STATE OF NORTH CAROLINA
DEPARTMENT OF TRANSPORTATION

Addendum No. 1

RE: Contract # C204286

I-40 FROM THE TENNESSEE STATE LINE TO MP-15

PROJECT REFERENCE NO.		SHEET NO.
I-5922	I-5923	2A-1
STATE PROJECT	F.A. PROJECT NO.	DESCRIPTION

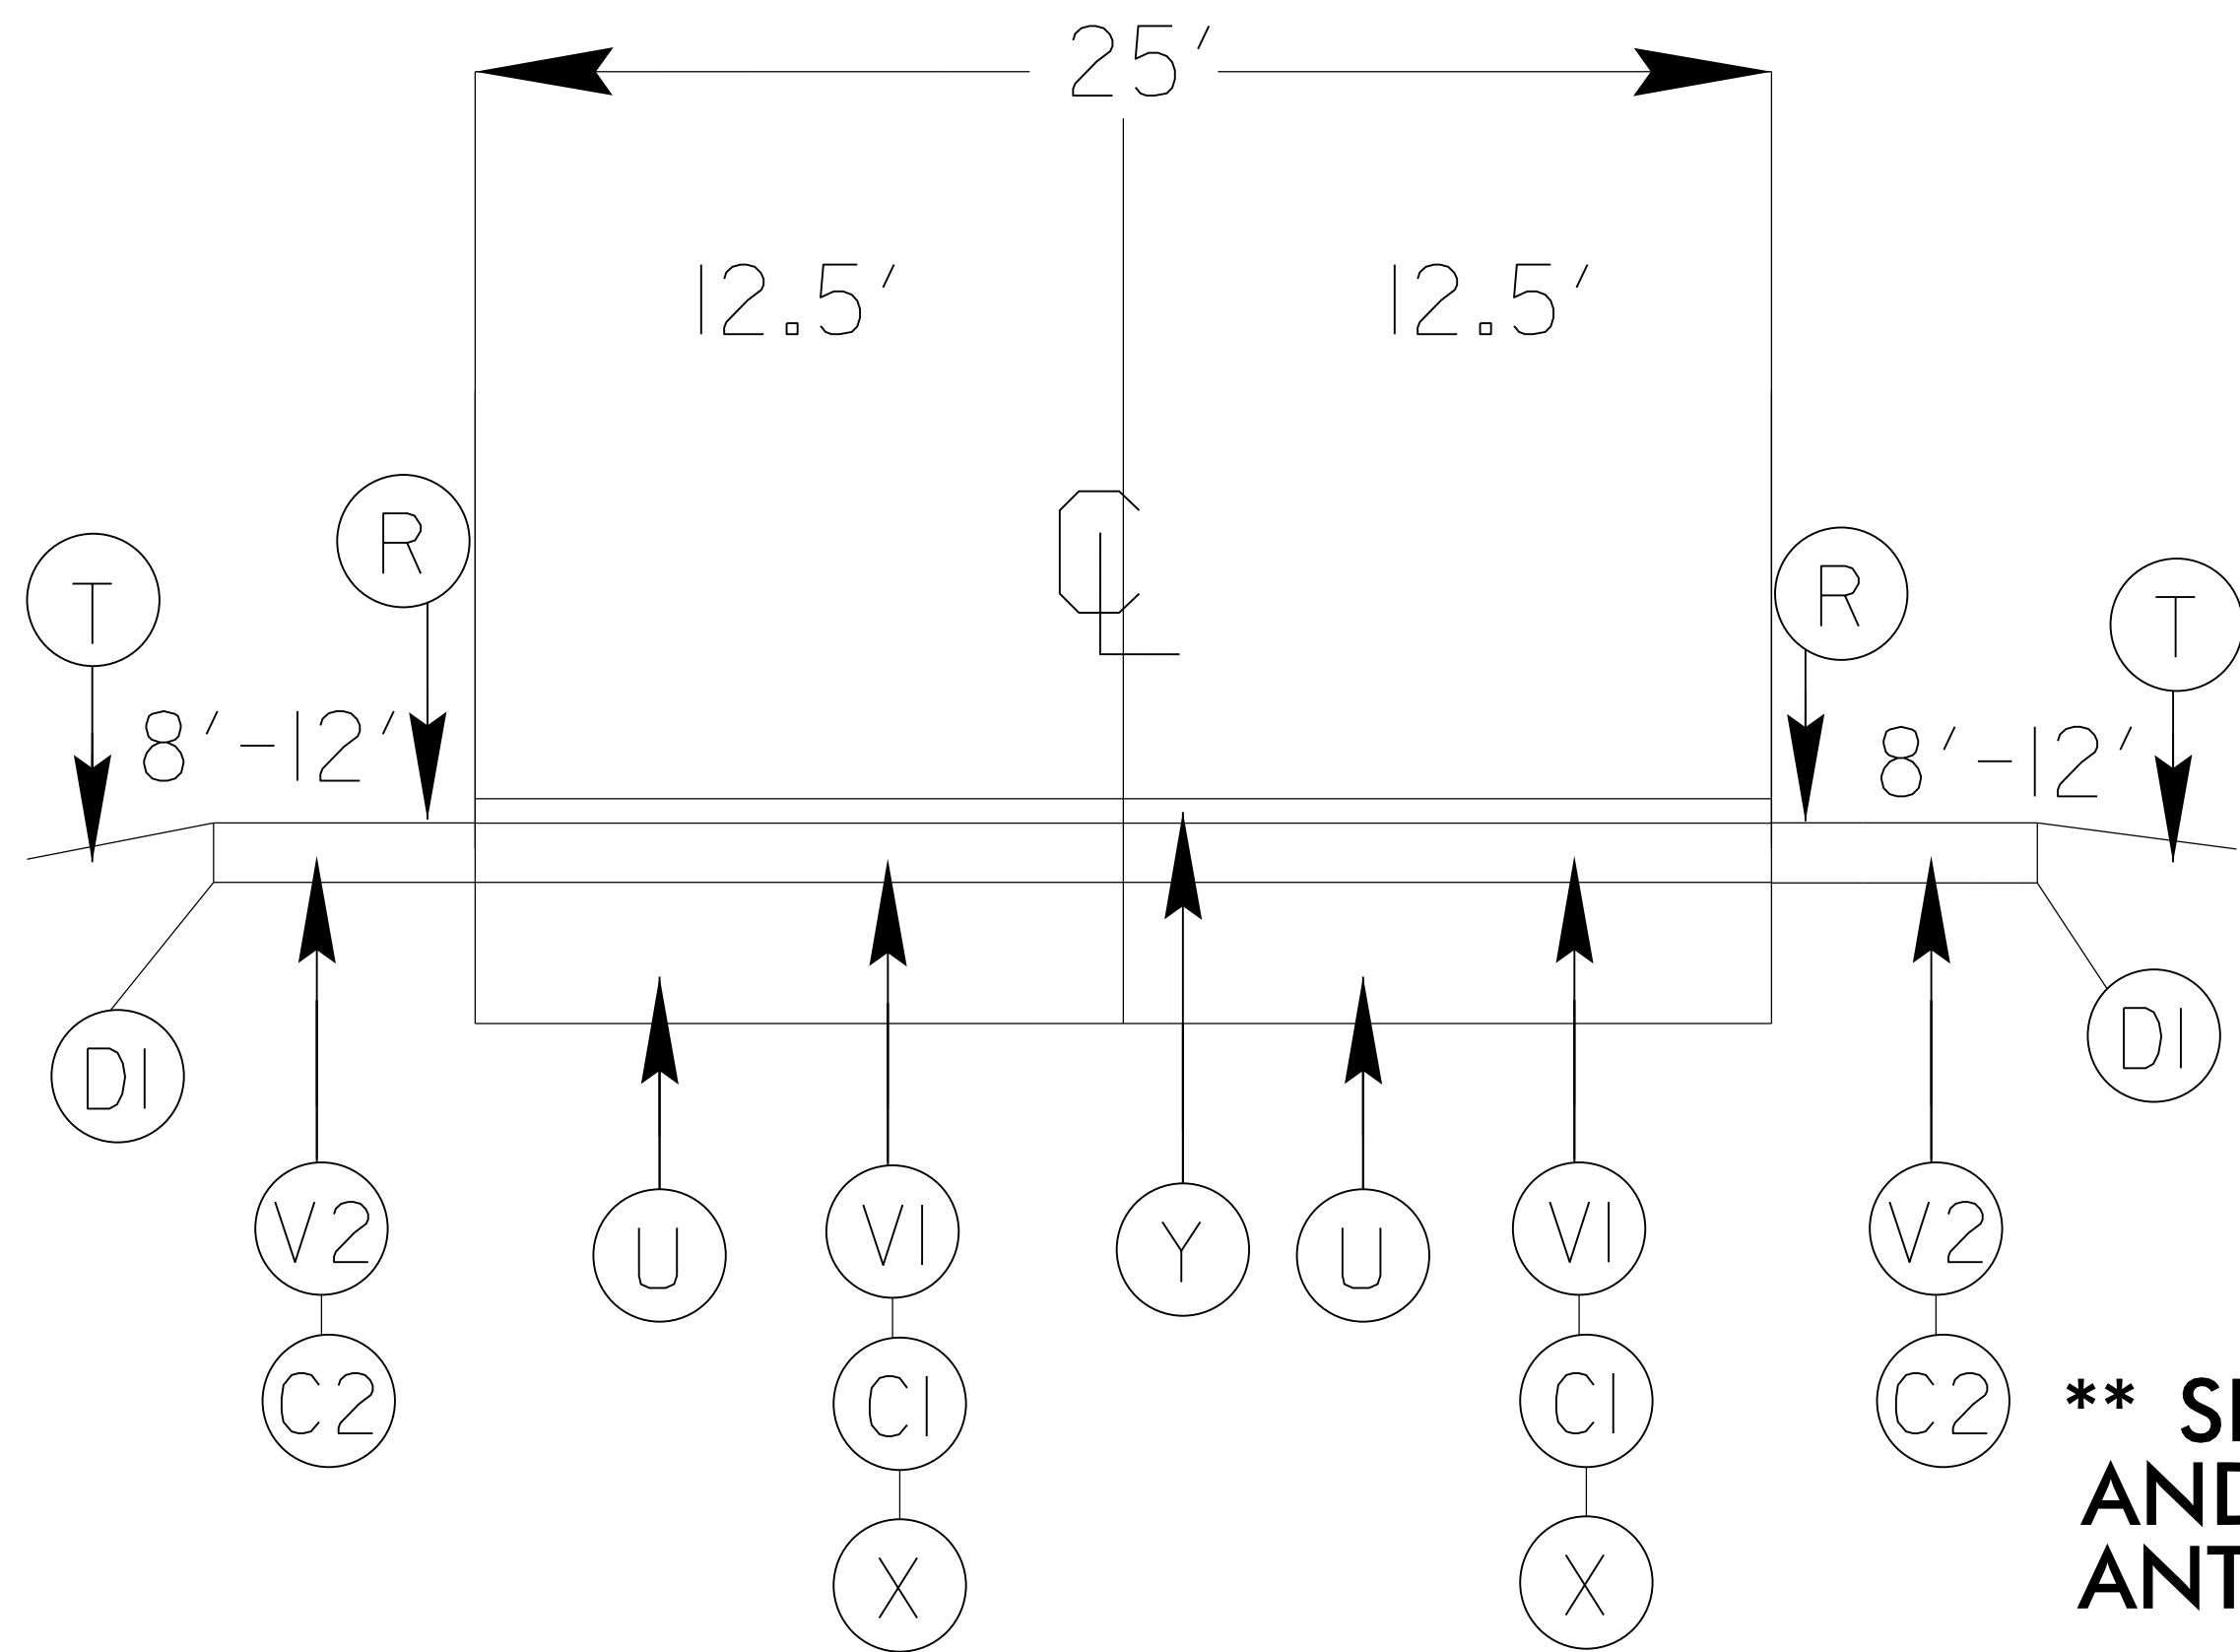
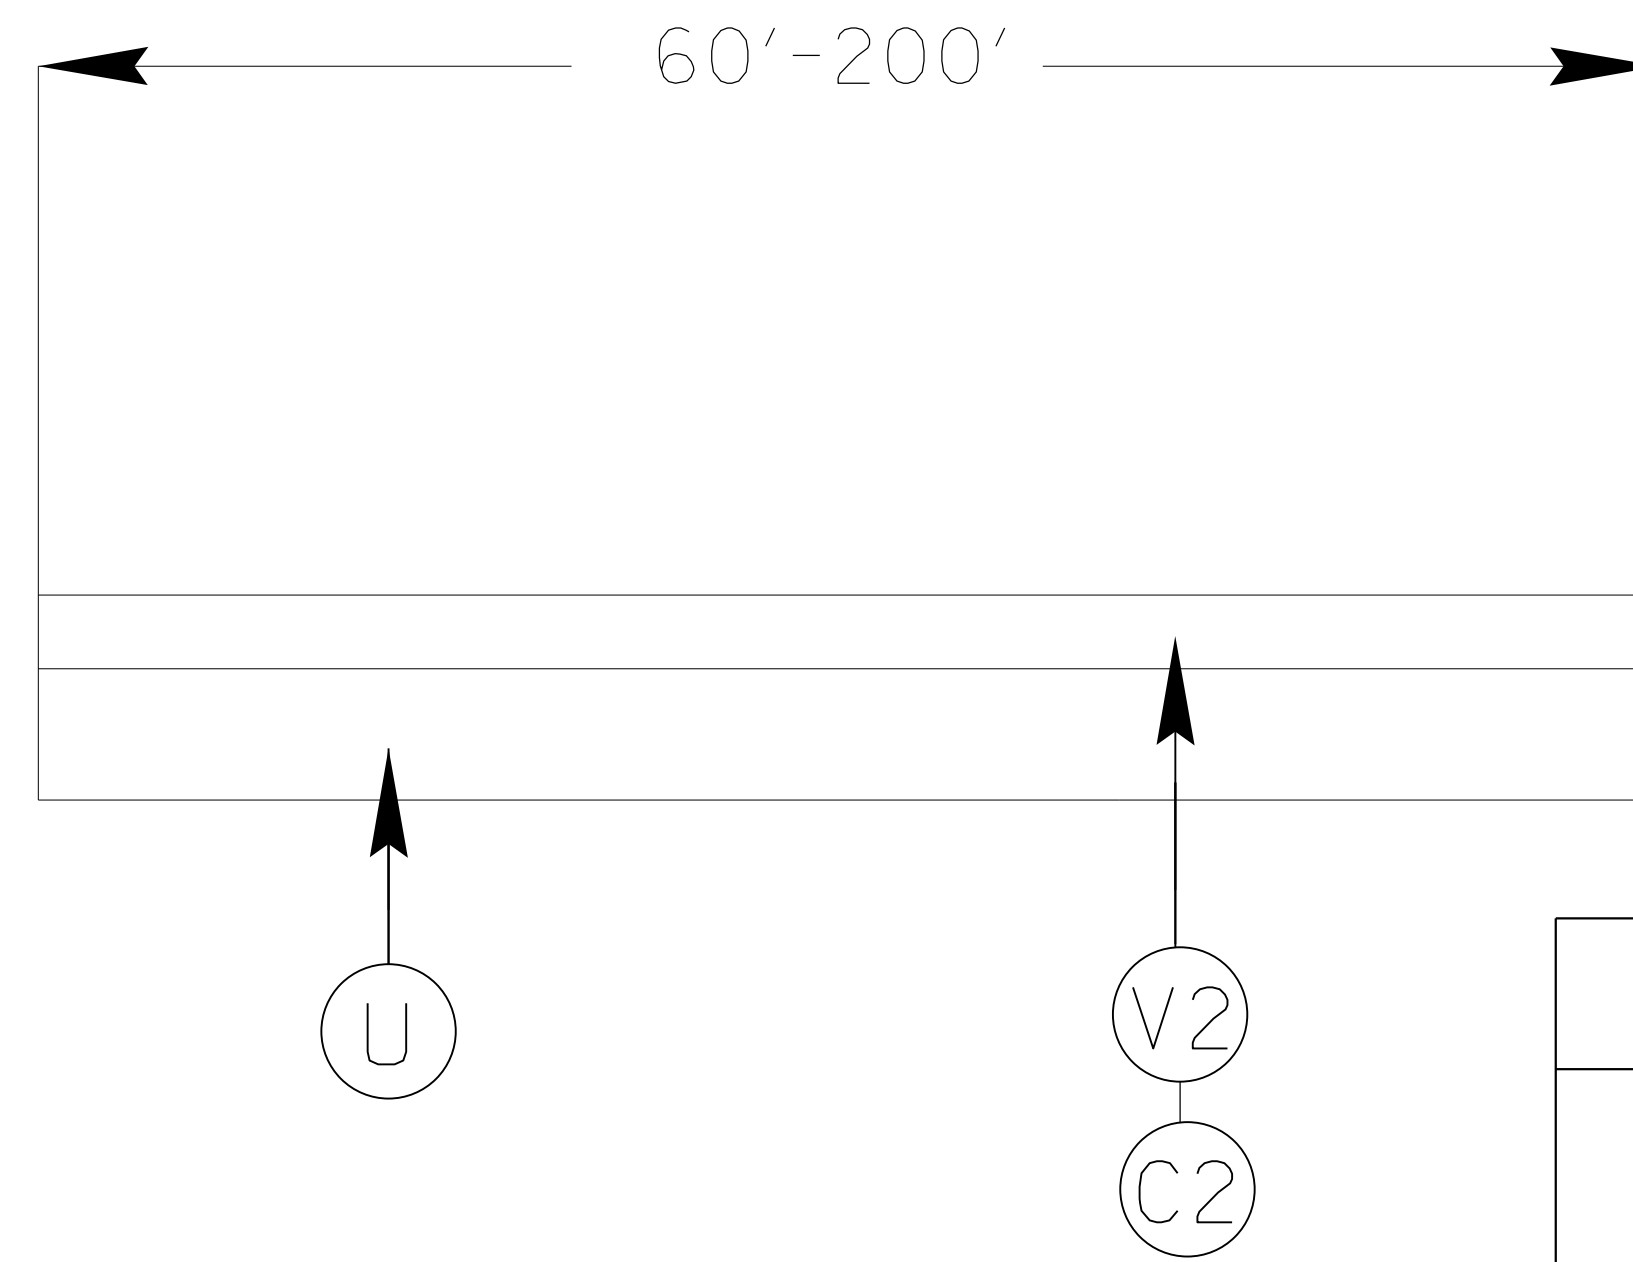
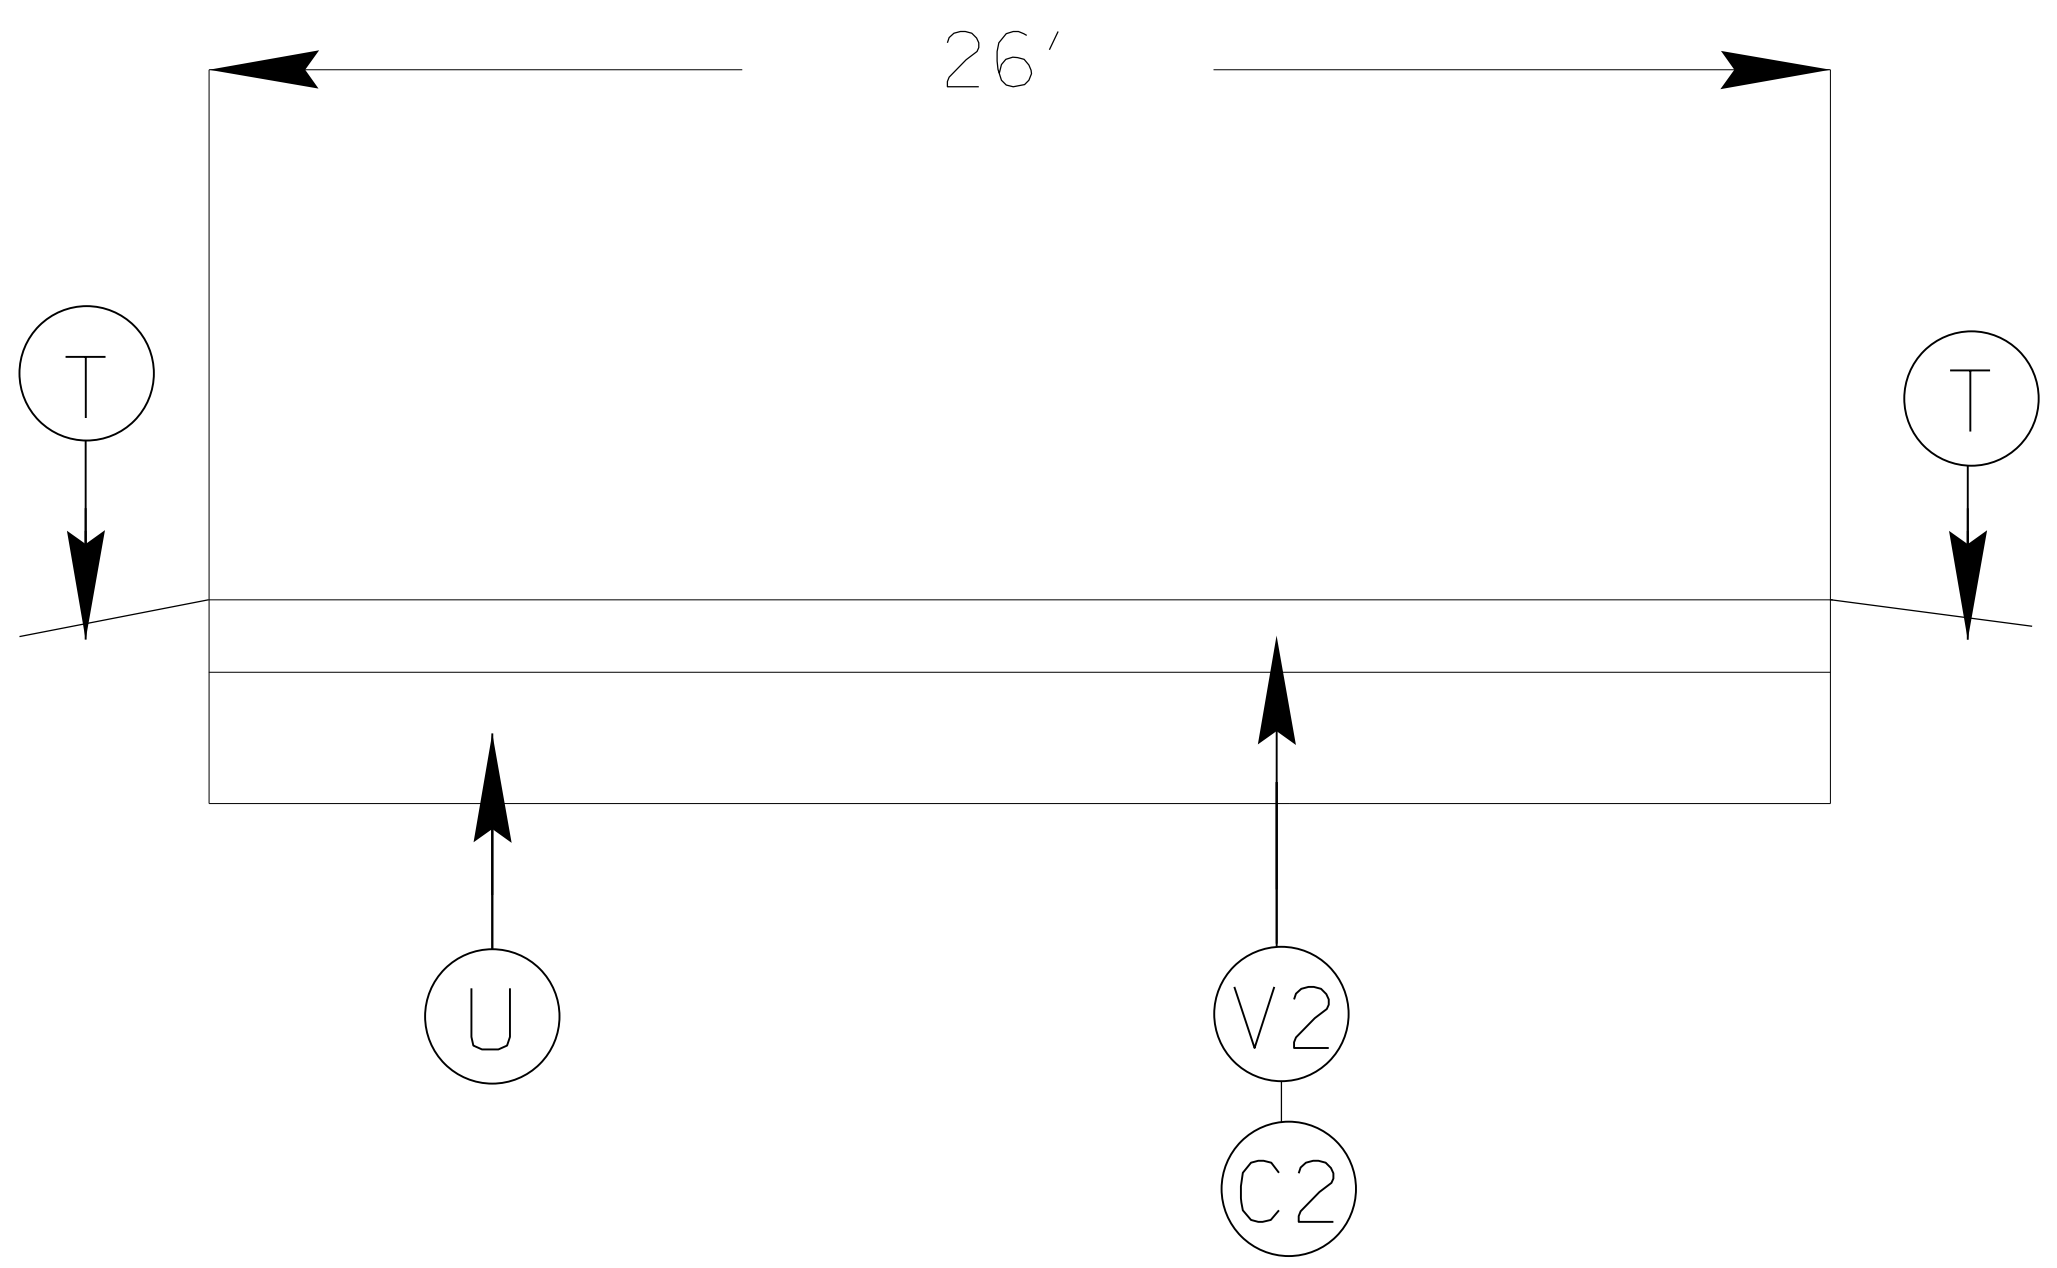
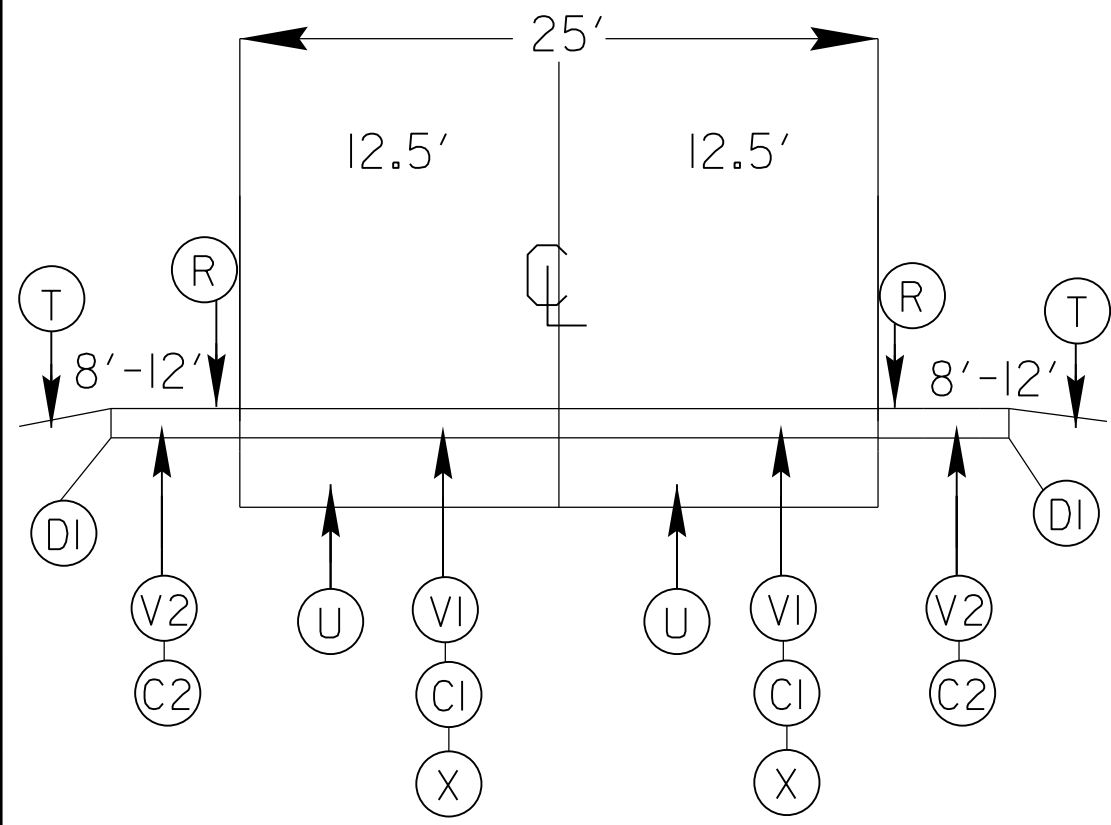
Sheet No.	Revisions
2A-1	Typical #1 revised to depict existing OGAFc layer and a note added.
